HPG RESPONSE TO TARONGA ZOO SKY SAFARI RESPONSE TO SUBMISSIONS AND AMENDMENT REPORT FOR SSD-46807958

Headland Preservation Group

10 June 2025

HPG'S OBJECTION

Figure 4 Lower station ground floor plan

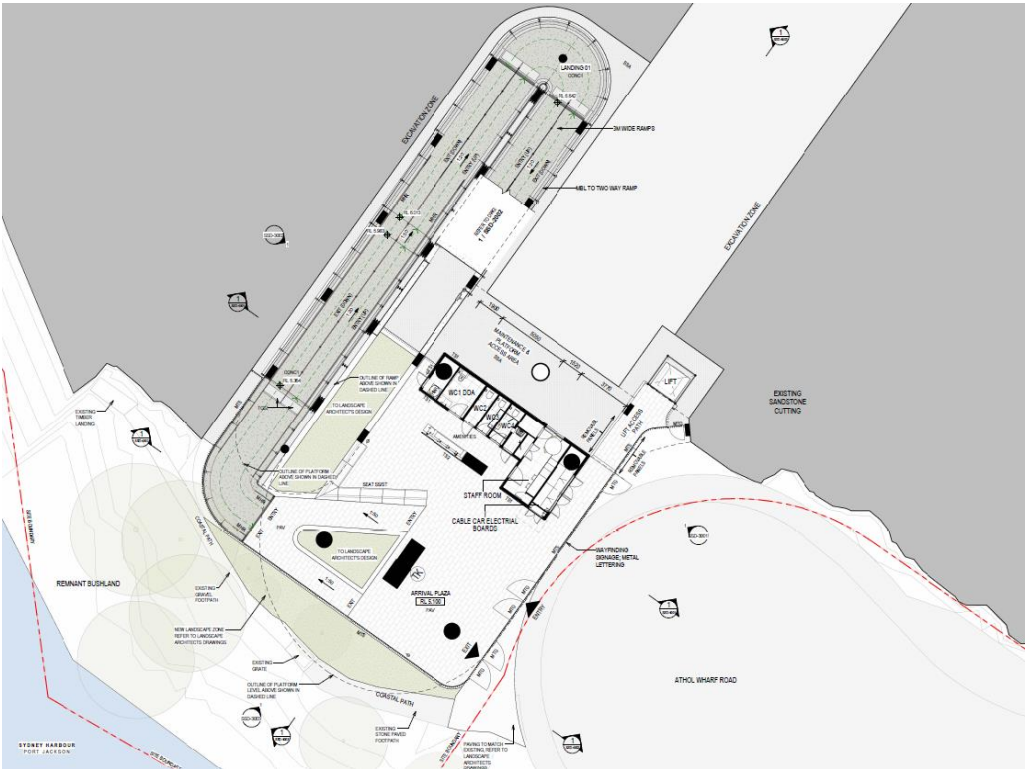
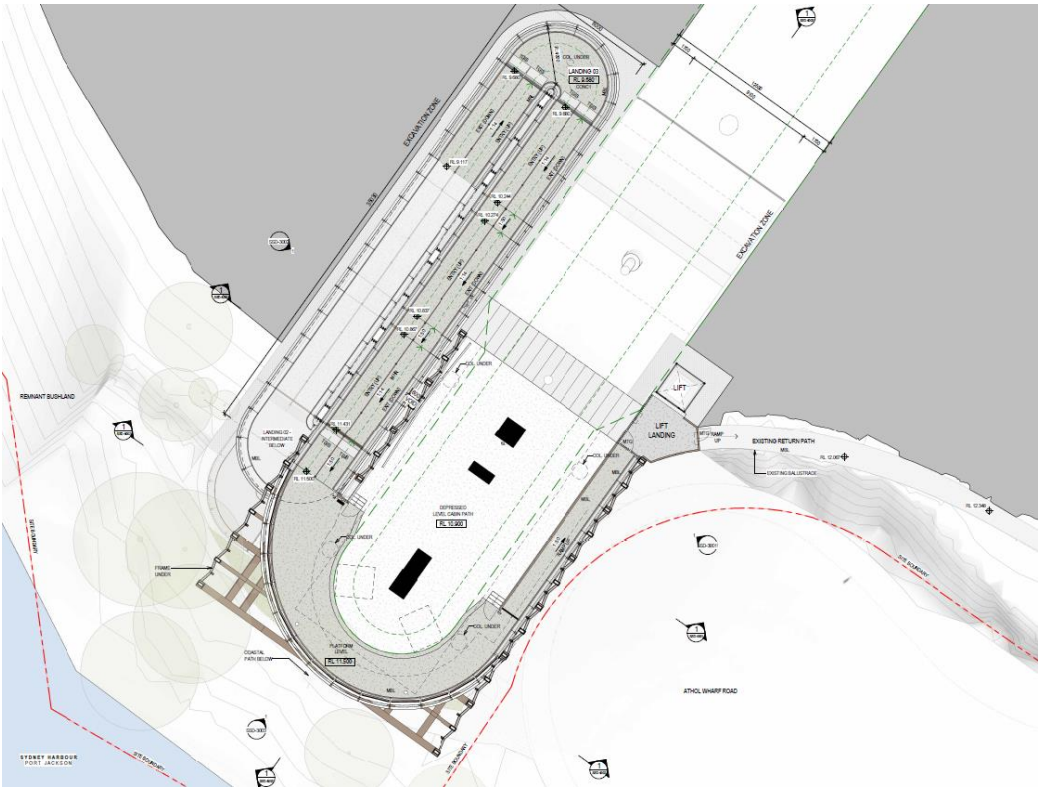
The Lower Station is a large structure. Whilst an attempt has been made to create a structure that fits into the landscape with well considered design elements, it will be a very dominant feature visible from a distance. Granted, moving the ramp from the eastern side to the western side will create a less intrusive visual from the street approach. The disturbance of the landscape, however, and **removal of 55 trees is significant**. There is no illustration showing how the Lower Station will now look from the western side. HPG presumes the removal of the 55 trees will expose the larger structure to western viewpoints.

Likewise, the most significant amendment in the revised EIS is the expansion of the Lower Station and the repositioning of the ramp and entrance. As noted, this involves removal of 55 trees. However, there is no attempt to illustrate this change to the design and the western aspect of the Lower Station. There is only an architect's plan which the layperson can find difficult to visually interpret.
